From: Judith Ward <Judith.Ward@Cherwell-DC.gov.uk>
Sent: 22 January 2020 12:48
To: Bob Neville <Bob.Neville@cherwell-dc.gov.uk>
Subject: 19/02948/F Land to S and adj South Side Steeple Aston
Hi Bob

The Planting and layout plan needs some comment:

Appendix 1a: Landscape Masterplan

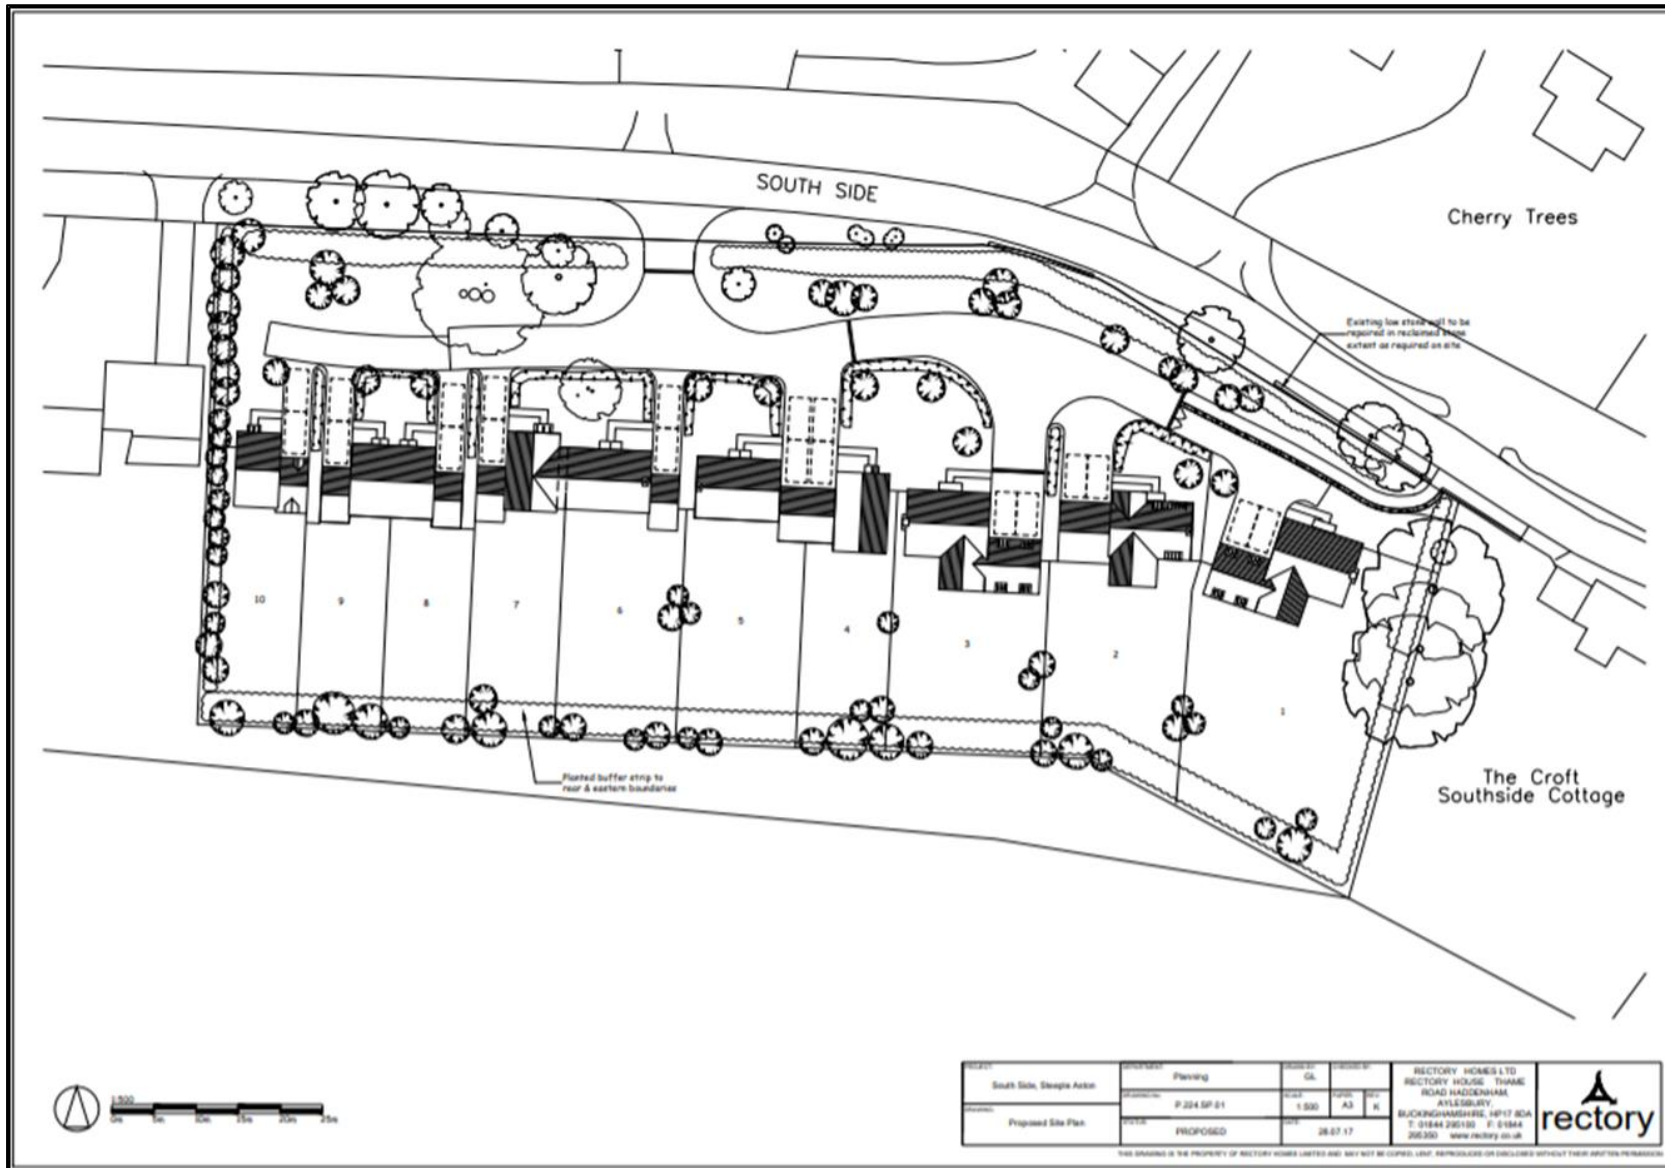
Firstly gravel cannot be compacted so the path within the open space needs to be compacted stone not gravel.

Routes into rear gardens are blocked by fences. It would be far more useful to have paths and gates into back gardens to allow for maintenance access.

The native buffer mix should omit *Ionicera* and *Rosa* as they will smother the other young plants (they will move in later anyway once the hedge is established). *Prunus spinosa* should form no more than 10% of the mix as it establishes poorly. I would add *Viburnum opulus* and *Cornus sanguinea*. I am also concerned that there will be nothing to stop purchasers from removing the buffer or putting up inappropriate close boarded fences.

Rosa should be omitted from the native hedgerow mix.

The planting plan is too ornamental for a semi-rural site. I doubt if it will be maintained on the open space and should be simplified. Some of the *Acer campestre* would be better planted in the wildflower meadow where they have space to spread rather than in the hedgerow.

Balls, pyramid and spirals of box and circular features are not appropriate. *Taxus baccata* berries are highly poisonous and not suitable for planting near houses where there are likely to be children. *Euphorbia* is also poisonous.
